From: Nick Thomas
Sent: 12 November 2024 18:21
To: Suzanne Taylor
Cc: DC Support
Subject: 23/01496/DISC UD Consultation Response.

Urban Design comments in relation to the amended Design Code Submission – Planning Reference: 23/01496/DISC

Mixed Use Framework Plan

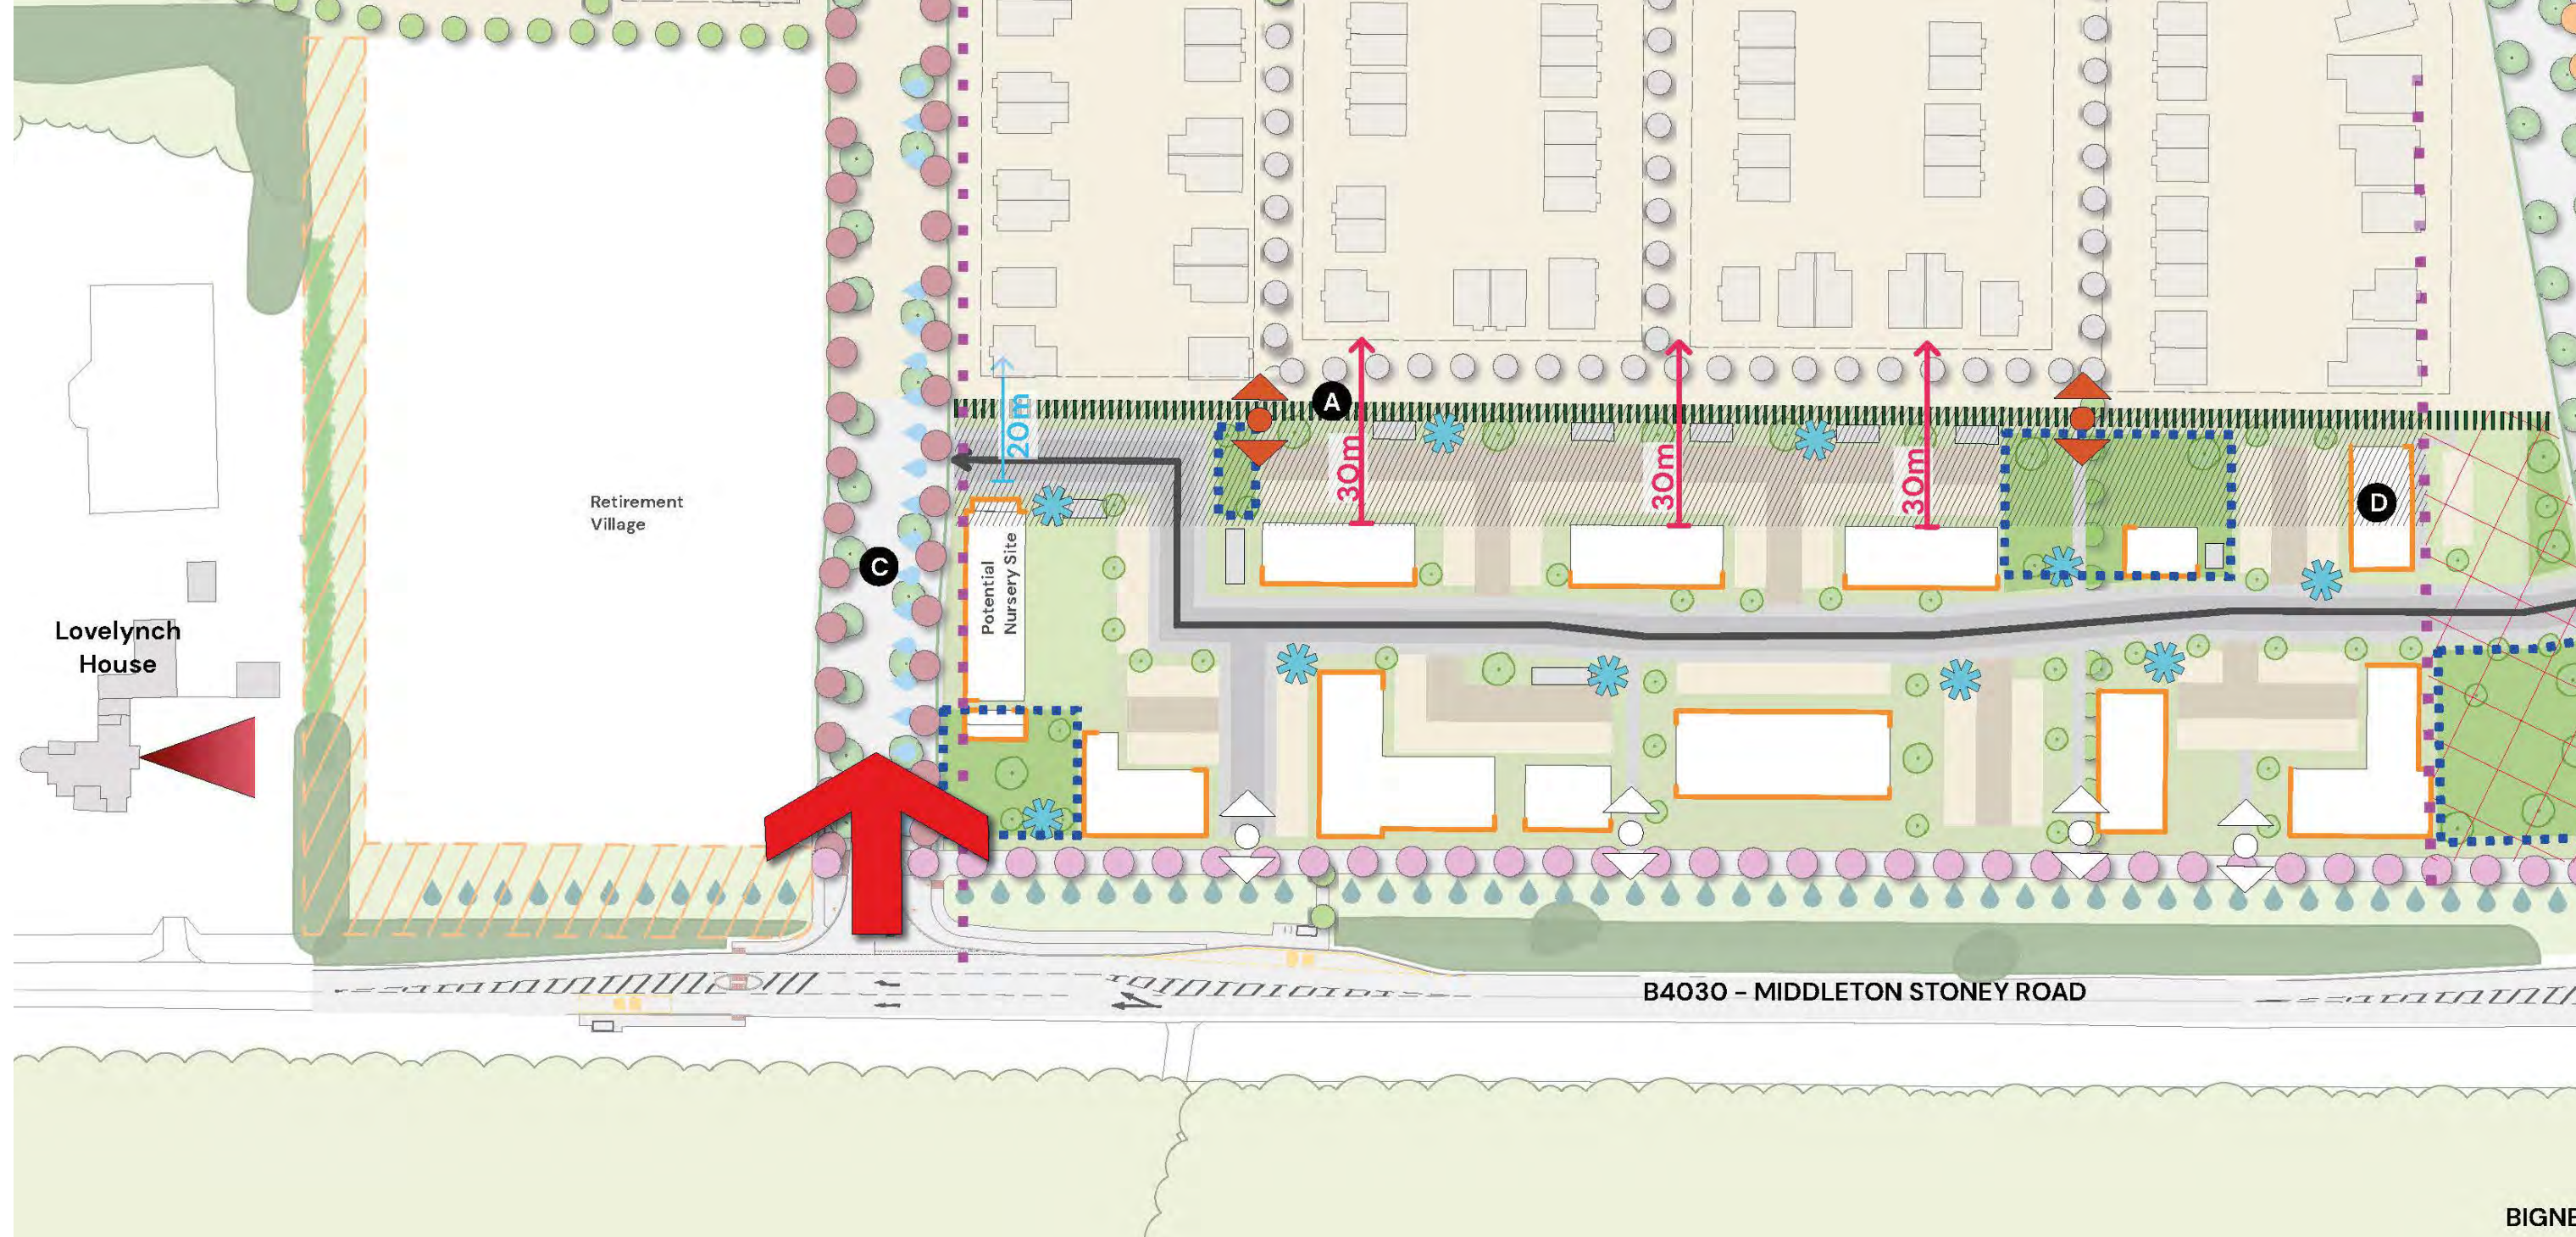
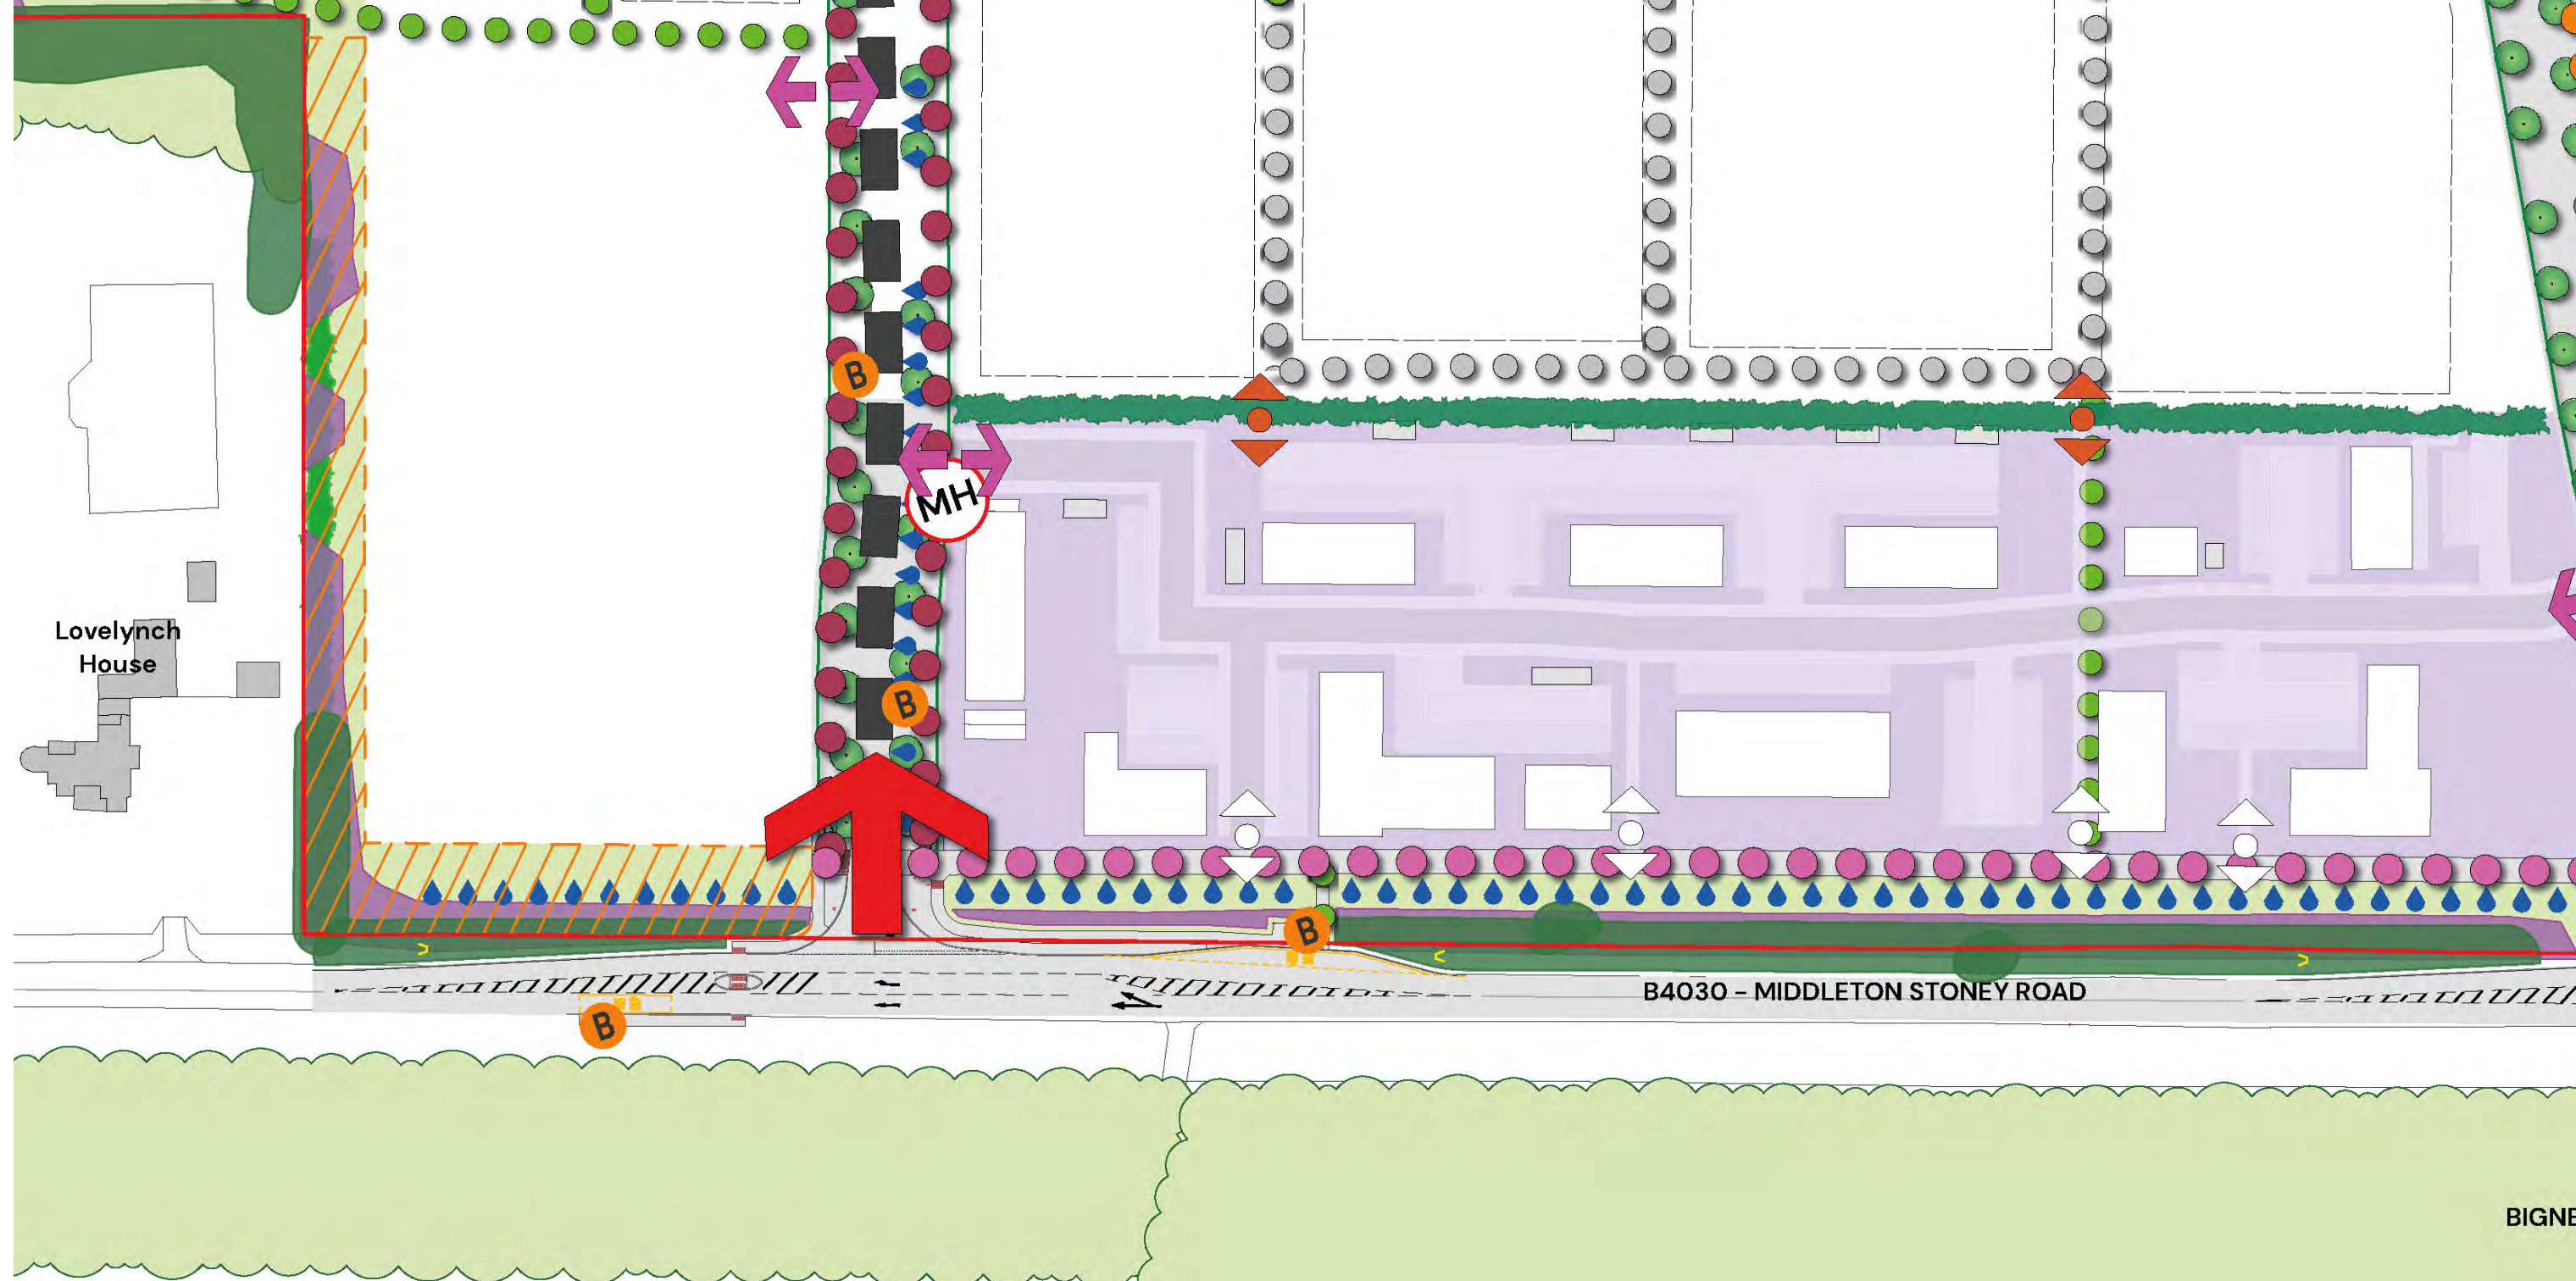
- Additional information added to the Regulating Plan to clarify when future linkages need to be delivered.
- Further detail added to the mixed-use neighbourhood centre to explain how this part of the site will relate to the adjacent residential areas including footpath links and frontages.
